## PARKS AND COMMUNITY SERVICES DEPARTMENT

August 28, 2024

**Subject: Grandview Reserve Phase II PUD Development Plan and Preliminary Plan, 3<sup>rd</sup> Submittal (PUDSP-23-006)**

LANDSCAPE
 PRELIMINARY LANDSCAPE PLAN (OVERALL)

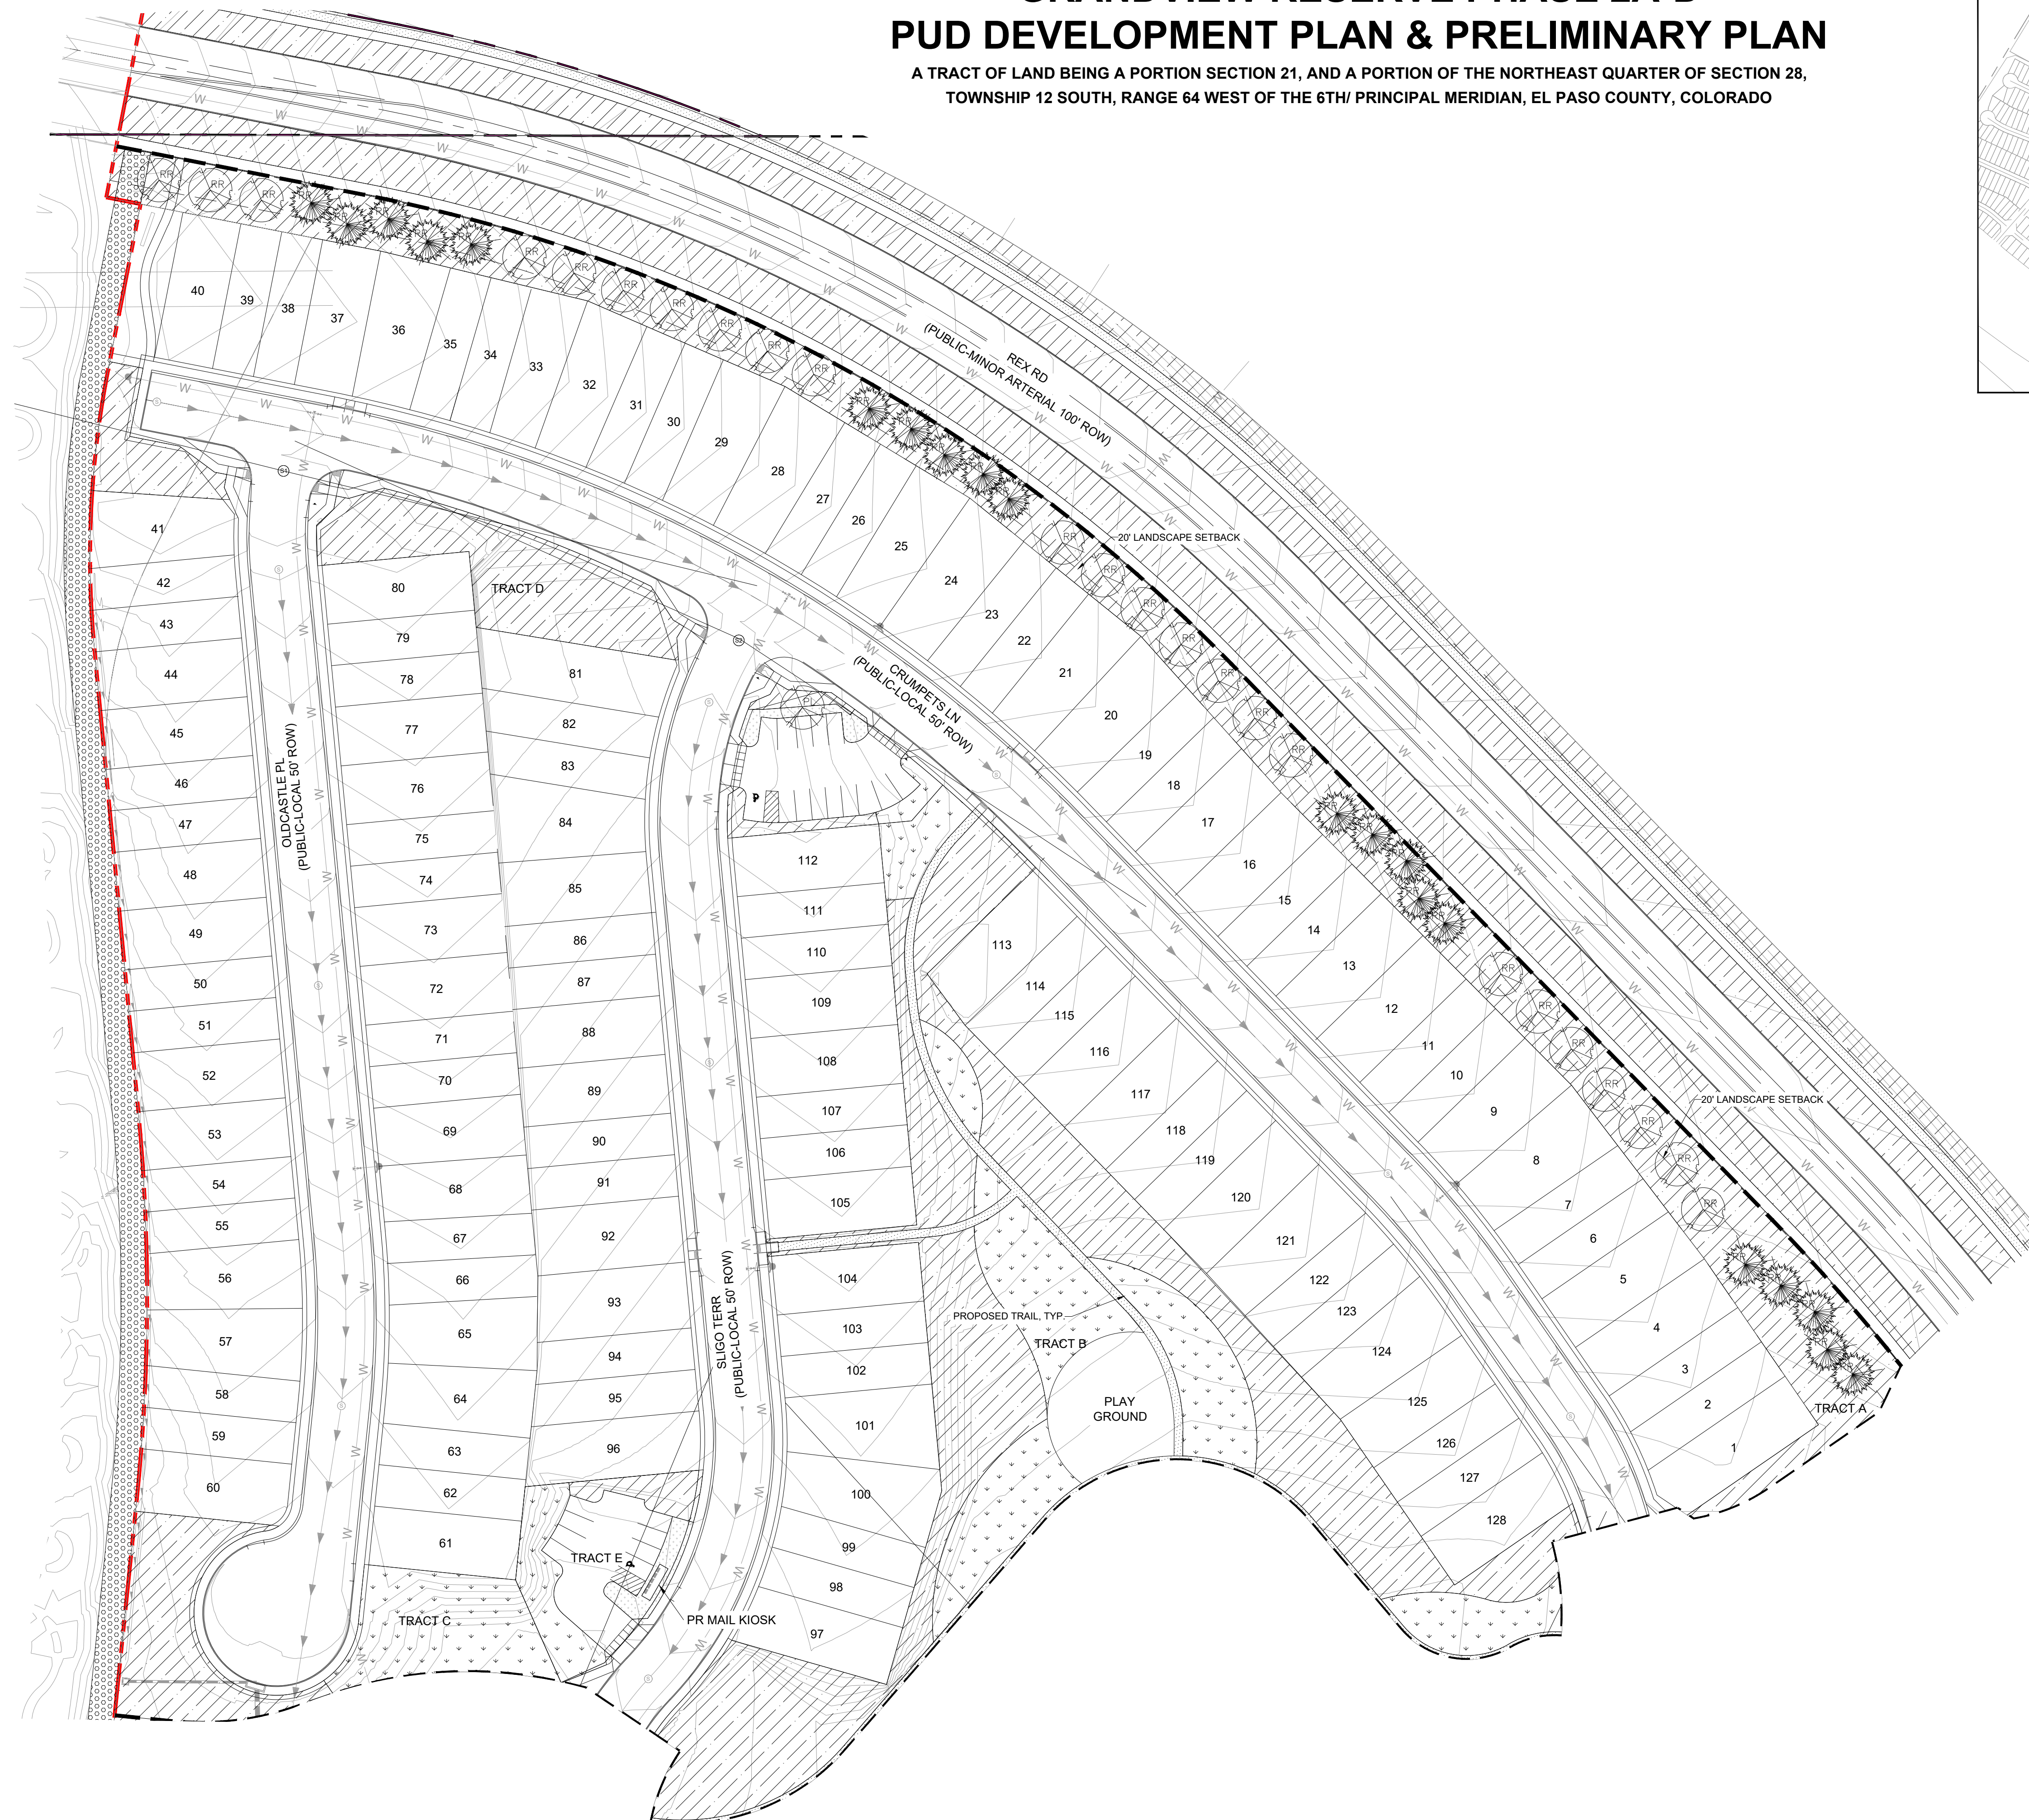
- The complete redesign of the lot layout, which has significant impacts on the configuration of previously designed parks, trails, and open spaces. The open spaces are still very well planned and the addition of the Tract B trail corridor will provide efficient off-street pedestrian access through the more dense portion of the development. **As a recommendation only and not a requirement, a connecting trail from Downpatrick Way to Dawlish Drive, perhaps in the vicinity of Lots 66 and 106, would allow for more expedited pedestrian access to the Tract I open space / park area.**

EPC staff is encouraged by the applicant’s willingness to provide extensive recreational amenities for its residents and citizens of El Paso County through the development of an expansive and connected park, trail, and open space system. Staff recommends that the applicant submit detailed site plans for the proposed neighborhood park and include multi-generational recreational amenities such as a playground, multi-use turf field, and/or seating and picnic areas. The submitted Landscape Plans are rather limited and only show half of the proposed park area.
